Our ref: AE/2022/127591
Your ref: EN010109
Date: 11 November 2022

APPLICATION BY EQUINOR FOR AN ORDER GRANTING DEVELOPMENT CONSENT FOR THE SHERINGHAM AND DUDGEON EXTENSION PROJECT

Please find enclosed our relevant representation for the Sheringham and Dudgeon Extension project

Figure 3: White-Clawed Crayfish Survey Results Map (River Tud, River Yare and River Tiffey)

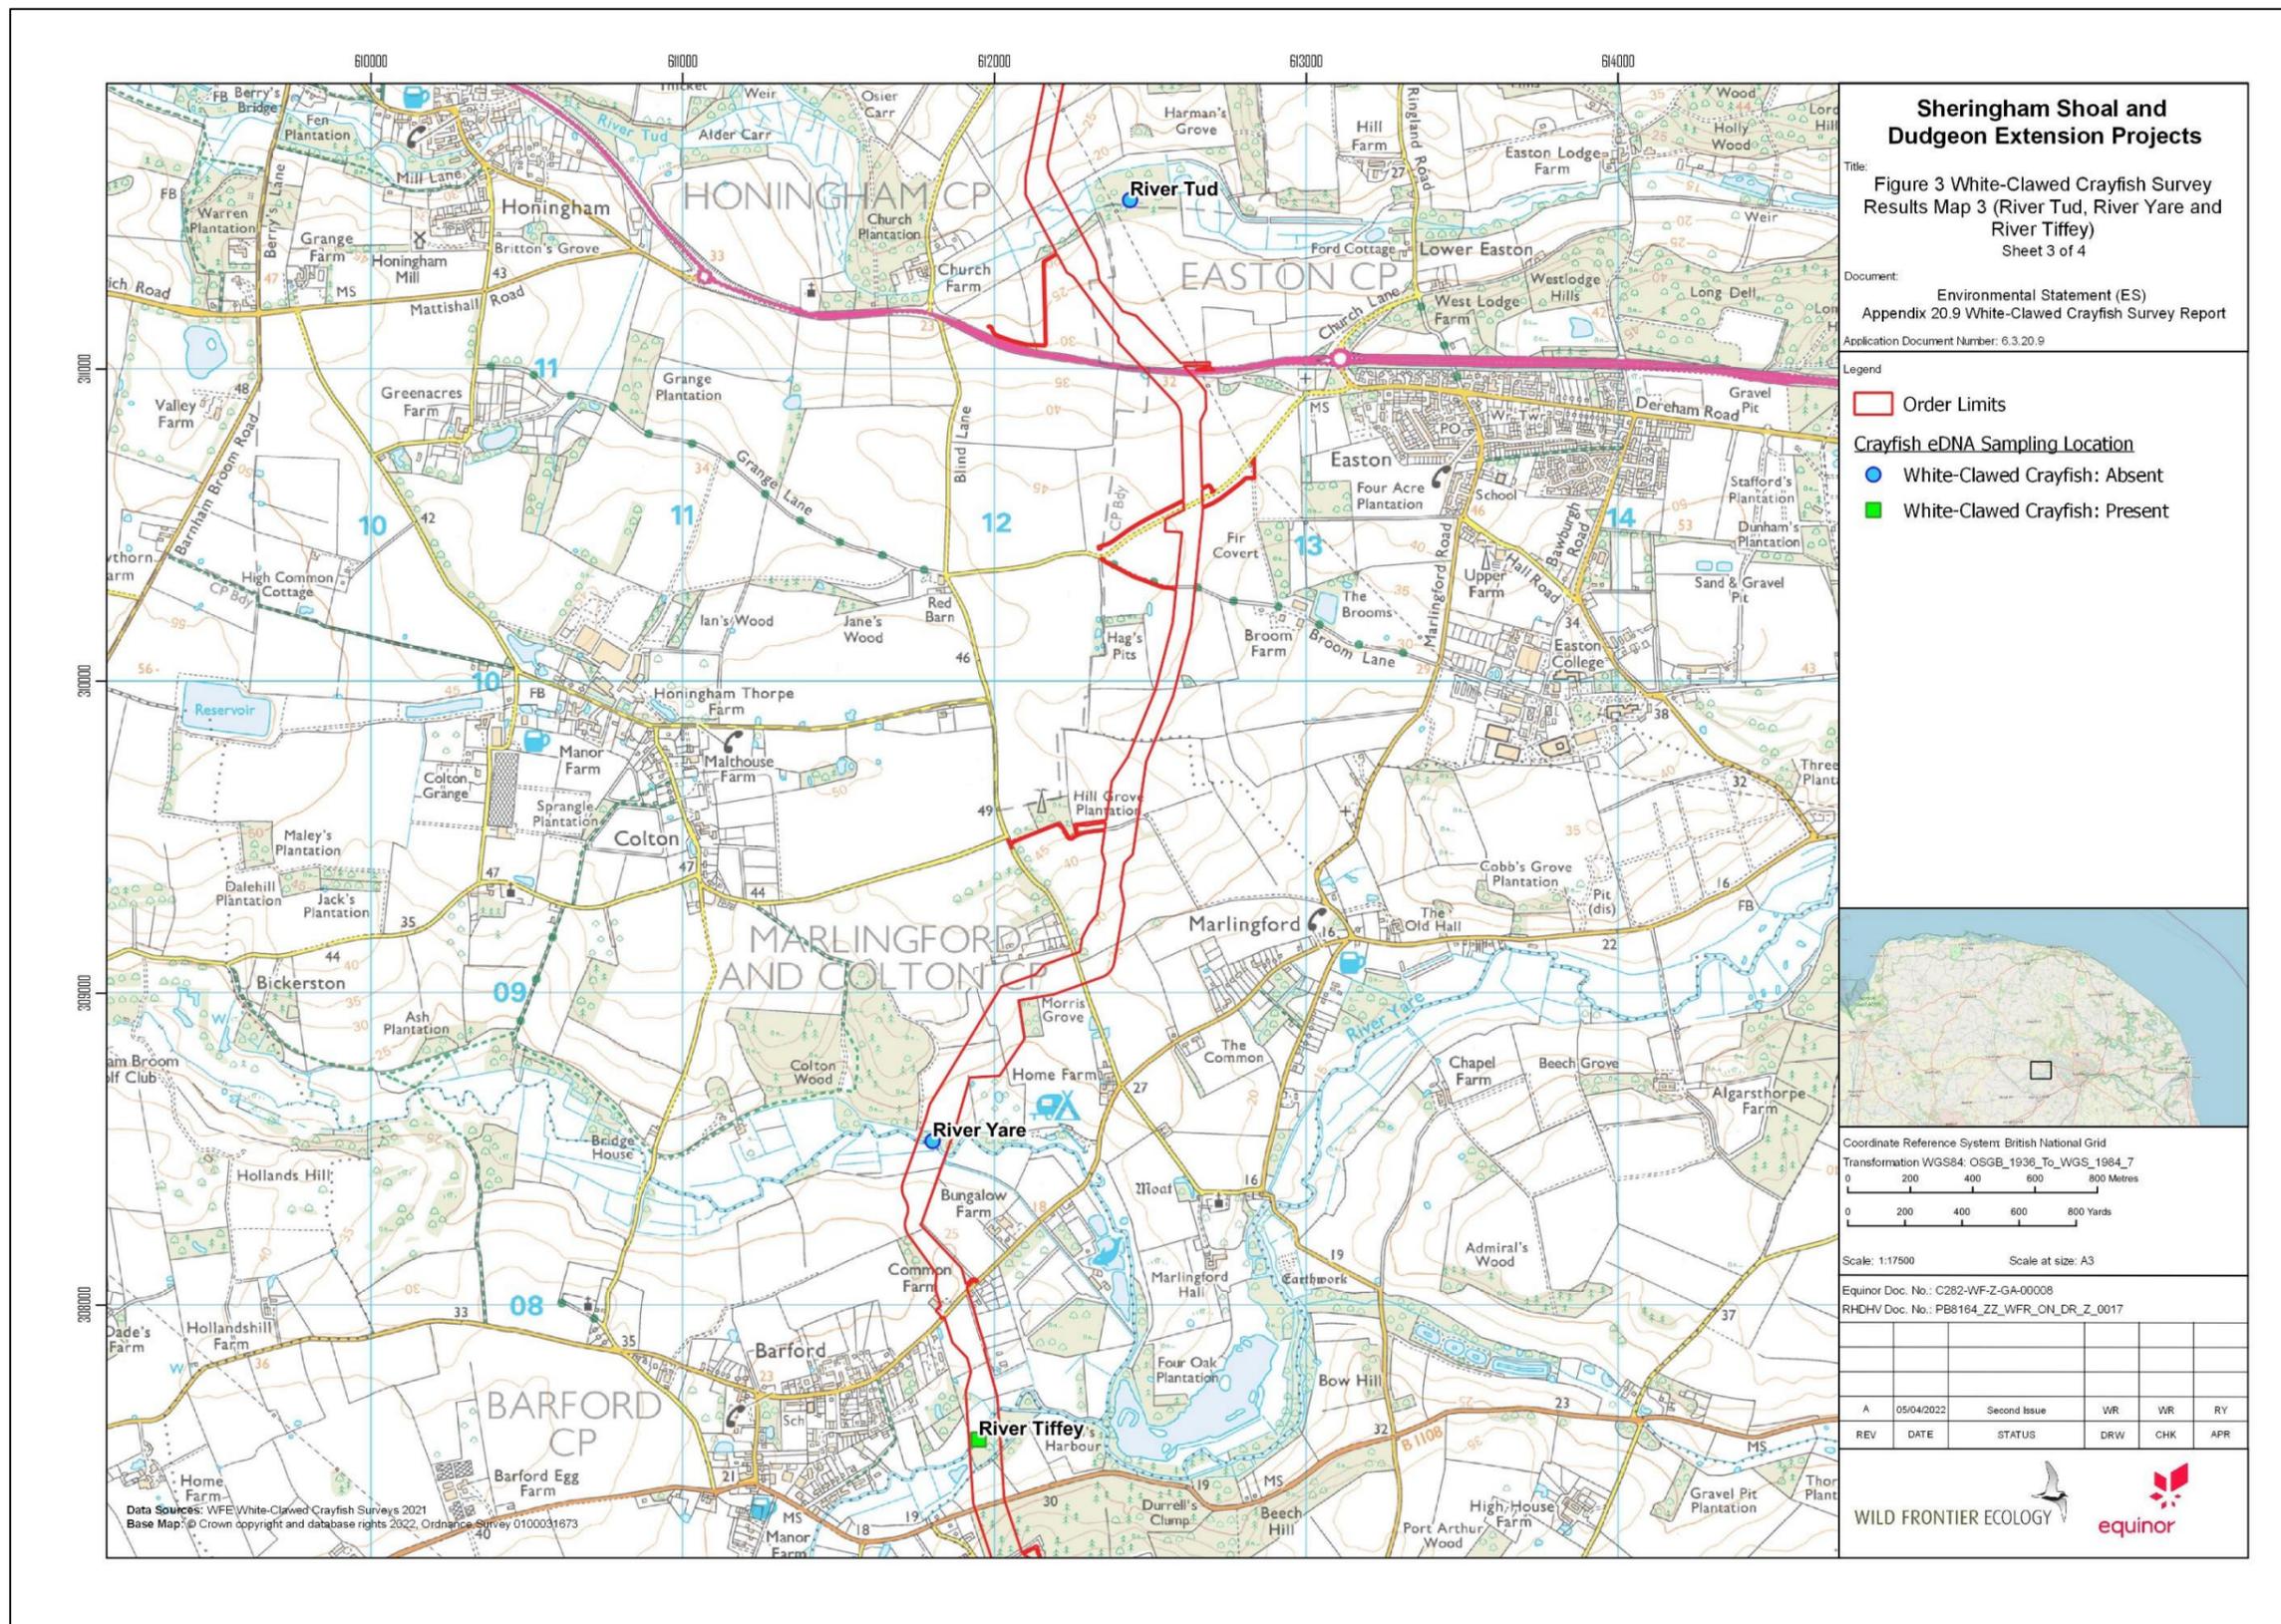
More recent surveys conducted by Norfolk Rivers Trust on the River Tud have produced a positive result for WCC (3 females). There have also been Positive results for WCC in the River Tiffey which were not previously known to be present in this river. Remaining WCC in the Tud are extremely vulnerable due to the presence of signal crayfish in the watercourse.

To address this, we recommend that extra vigilance regarding biosecurity is used when moving between and within river catchments.

If not already done, we request that the eDNA results for WCC are shared with the Norfolk Biodiversity Information Service (NBIS) and request that a copy of the report is also shared with the Environment Agency.
